Please ask for: Ms Iqraa Malik
Email: iqraa.malik@terraquest.co.uk
Telephone: 01212341390
Our Ref: M/64/21/HH
Your Ref:
Date: 7th May 2021

Application for Planning Permission for Works or Extension to a Dwelling

Development: Installation of a timber structure in rear
Location: 132a Elmer Road Bognor Regis PO22 6HZ

new garage

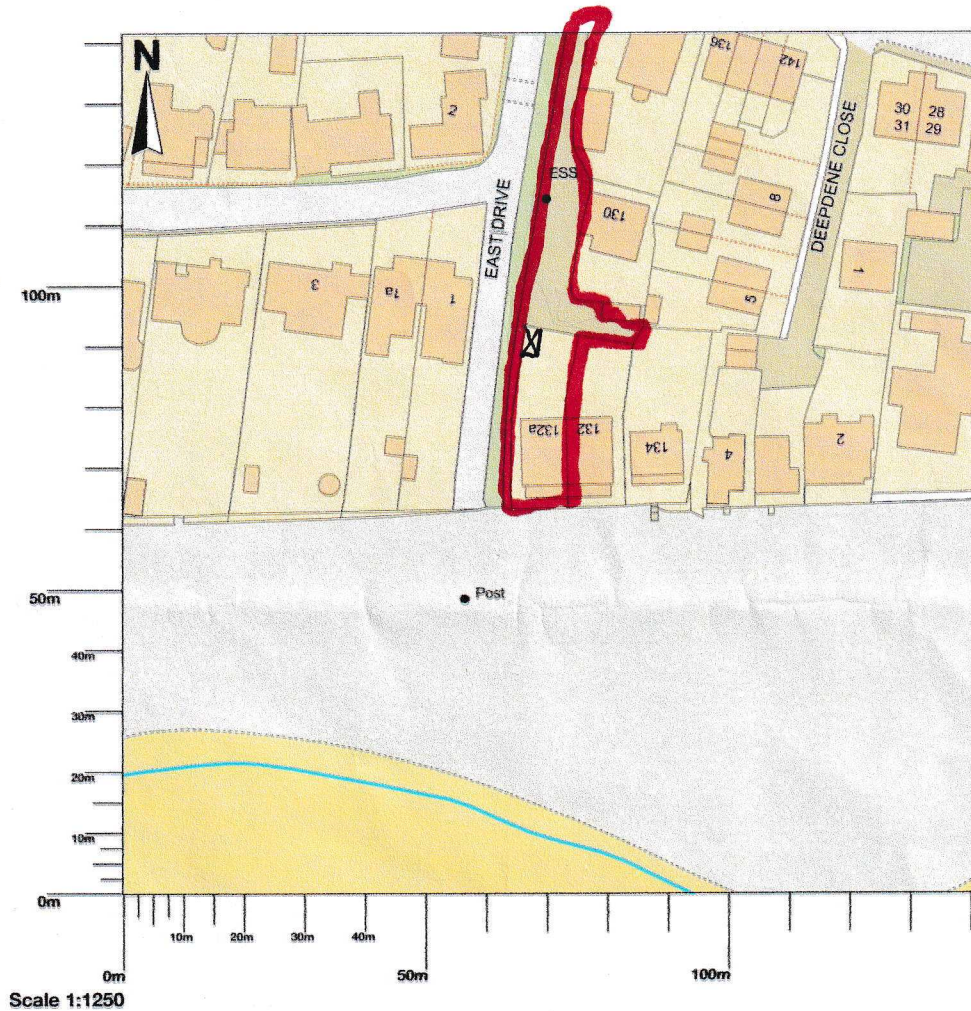
Block Plan

You are required to have dimensions from the proposed extension(s) to all site boundaries. Please amend.
